**Oberon White Granite Quarry Project (07_0122)
Submission against the Expansion of the Existing Quarry**

RE: OBERON WHITE GRANITE QUARRY

Further to your request I confirm my verbal advice there are a number of errors in the acoustic assessment prepared by Spectrum Acoustics for the Mudjee Stone Company Pty Ltd proposed Oberon White Granite Quarry.

**Figure 3 - Surrounding residences**

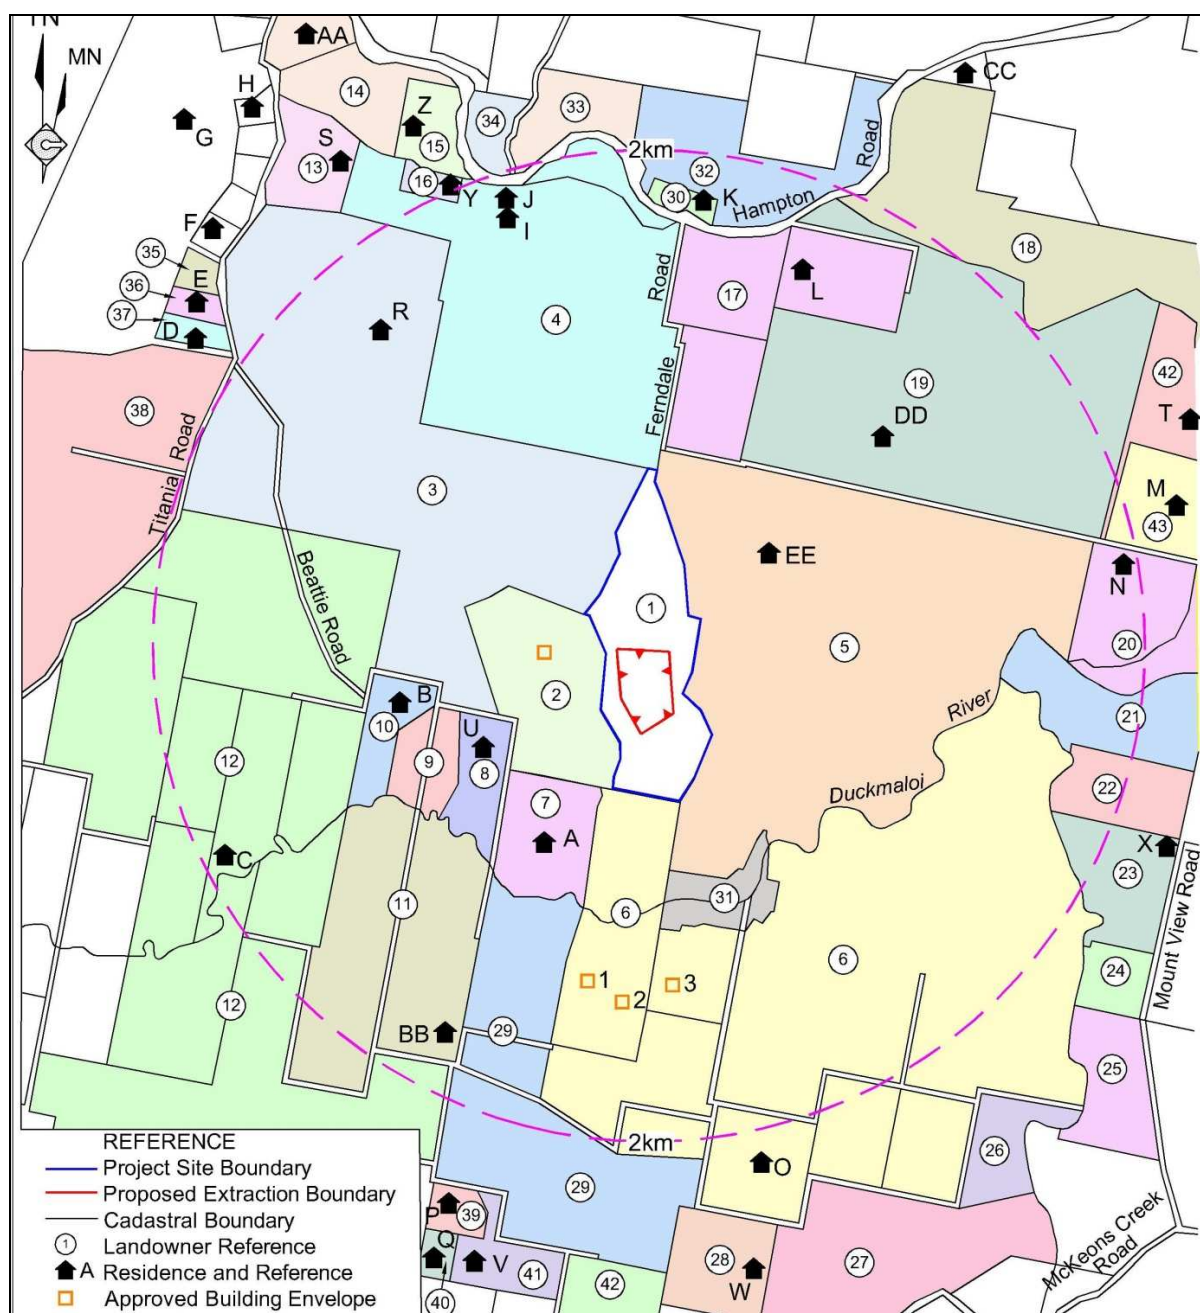
The client's property, in the name of Sutfol Pty Ltd, is shown at reference 11 on the map attached to the Environmental Assessment of RW Corkery & Co Pty Limited, in Section 4 at page 10. The arrow shown on the property marked "BB" is not showing the position of the residence.

Figure 1 does not show any residences between Burrough Crossing Road and the Duckmolo River. The client has indicated that their residence falls into this category and is not shown in Figure 1 of the acoustic assessment. Therefore the application requires an amendment to address the impact at the existing residence not included in the assessment.
